Our reference: DOC09/32631

Environmental Assessment Exhibition – Major Projects 08_0257 – Stage 1 – Residential Development and Major Project 08_0258 – Early Works Package 61 Mobbs Lane, Epping

Attachment 1: DECC Comments on Major Project 08_0257 61 Mobbs Lane Epping

Figure 6. 1943 aerial photograph of the Study Area (outlined in red). Features indicative of previous disturbance within the site (i.e. market gardening shown in green) are also shown. Source: RTA 2005¹¹

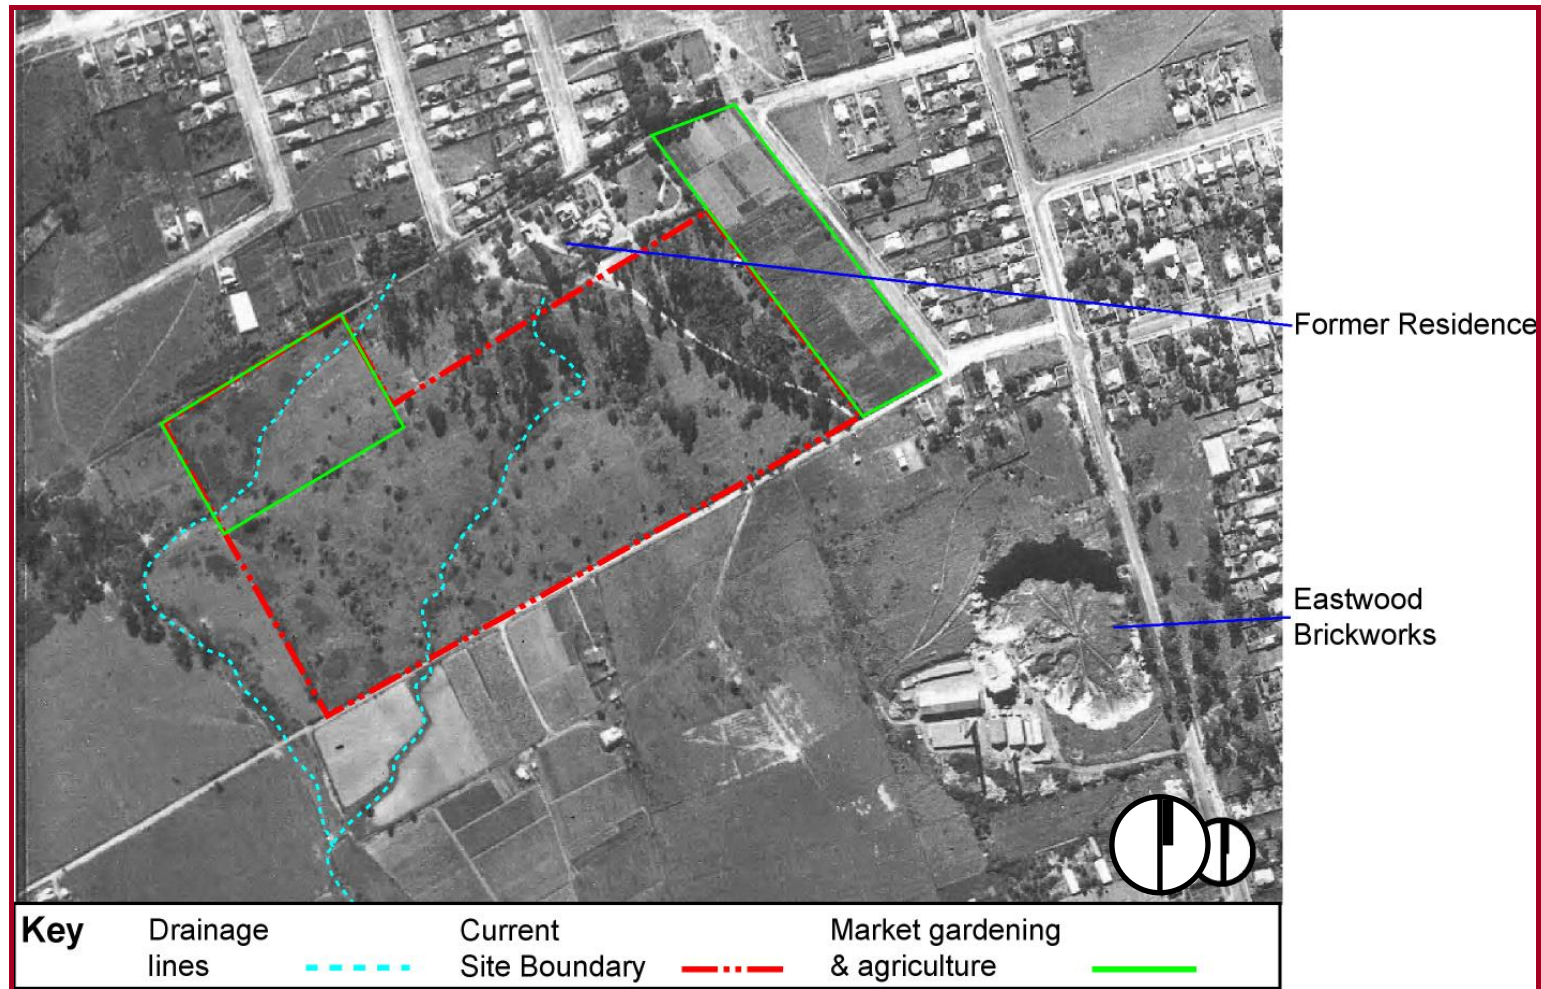
1. The area coloured orange in Figure 6 of the report has moderate potential to contain archaeological deposits and as such must be investigated by sub-surface investigations if the proposed development is to proceed.
2. The area coloured blue in Figure 6 of the report has no archaeological potential and thus presents no constraint if the proposed development is to proceed.
3. It is DECC's understanding Aboriginal Heritage Impact Permit approval is not required. The consultants report presents a different interpretation (refer to page 13 of the report). Please confirm the DoP's position on this.
